**One Earth Solar Farm (Application No. EN010159)**

**South Clifton Parish Council (SCPC) - Reg. No. F950A45AB**

**Deadline 4 submission – Tuesday 14<sup>th</sup> October 2025**

**Comments on any additional submissions received by D3 and accepted by the ExA**

Figure 4.1: Barred Route Plan

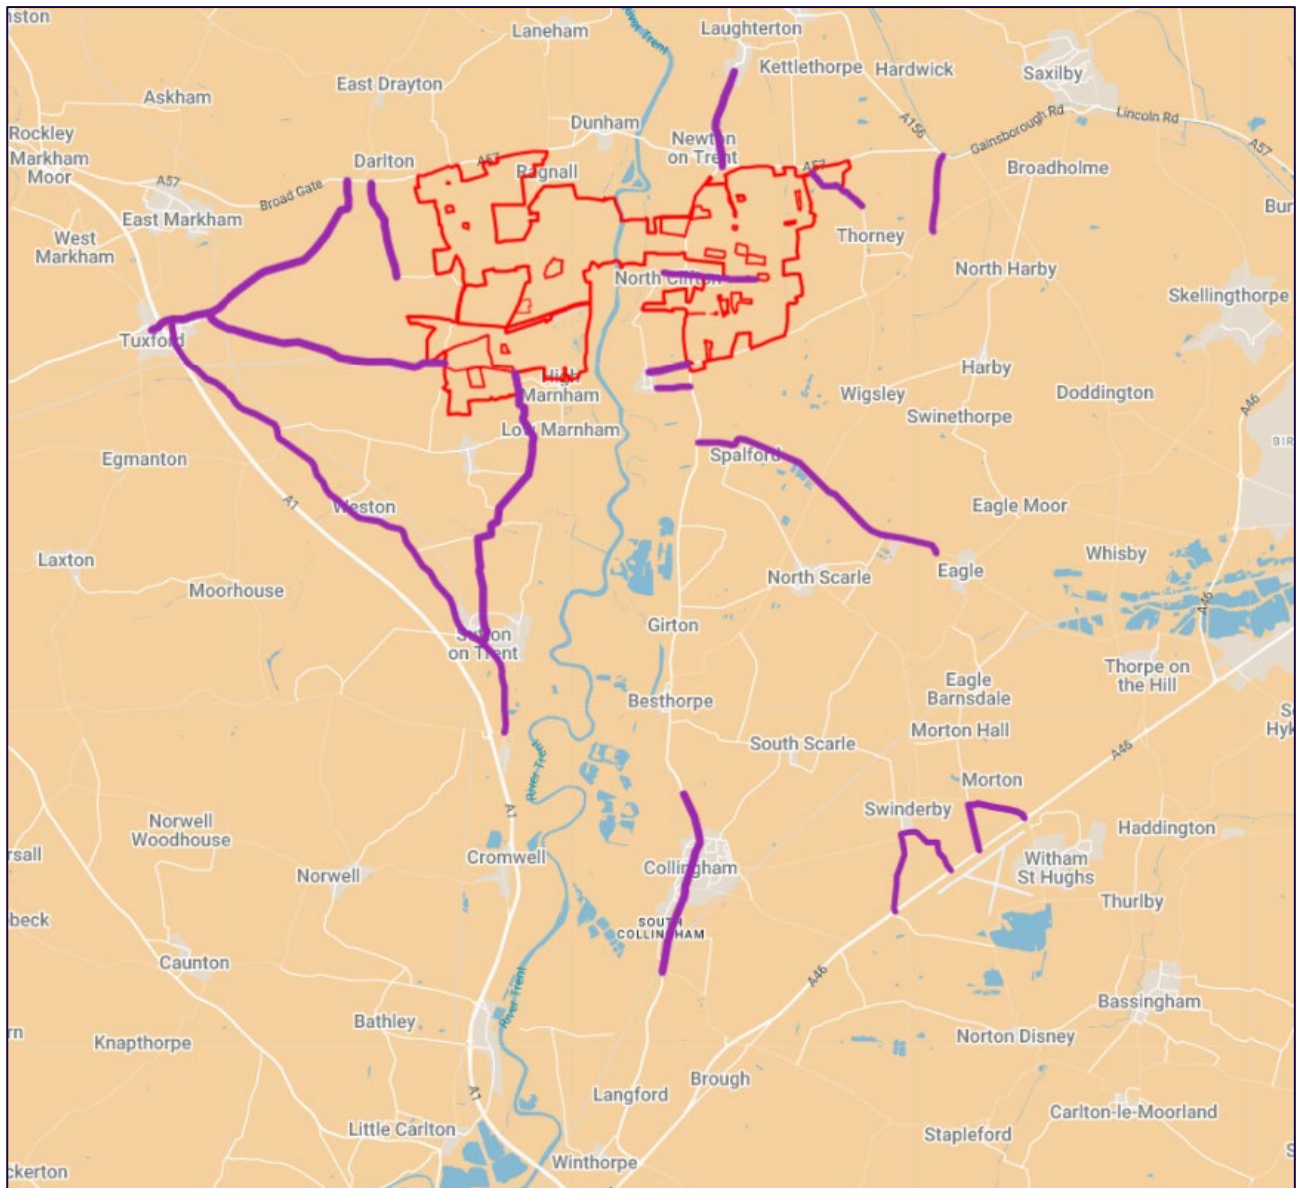
**2 – The inclusion of Moor Lane, South Clifton as a barred route.**

Moor Lane, South Clifton is a popular route between the A1133, Thorney, Wigsley, Harby and onward to Lincoln. It is a very poorly maintained road where 2 cars can pass in opposite directions with extreme care. It is also used by lorries from local businesses and also farm traffic, tractors etc. In this case, any oncoming traffic needs to pull over to allow the larger vehicles to pass, as the width of the road does not allow safe passage.

There is a blind bend on this road, near Cosy Cottage, which causes problems for motorists, cyclists and horse riders. Any vehicle rounding this bend, especially at speed, can force other traffic into the ditch, which has happened.

The applicant has proposed 2 site entrances on Moor Lane near the A1133 and also one off the A57 at Thorney. SCPC is concerned that the use of Moor Lane between the A1133 and A57 Thorney by construction traffic would present a great danger to other users of the road and suggest that this road is classified as a barred route, ensuring that all construction traffic utilises the roads within the site.

At South Cliftons first meeting with the applicants' team, we were assured that there would be only one entrance to the site on the East of the river, which is the first one on the A1133 as you turn off the A57. We were told all other movement would be within the site boundaries. We, even at this early stage, highlighted the danger areas on the A1133 and the unsuitability of Moor Lane, South Clifton. The applicant has failed to consider this issue adequately.
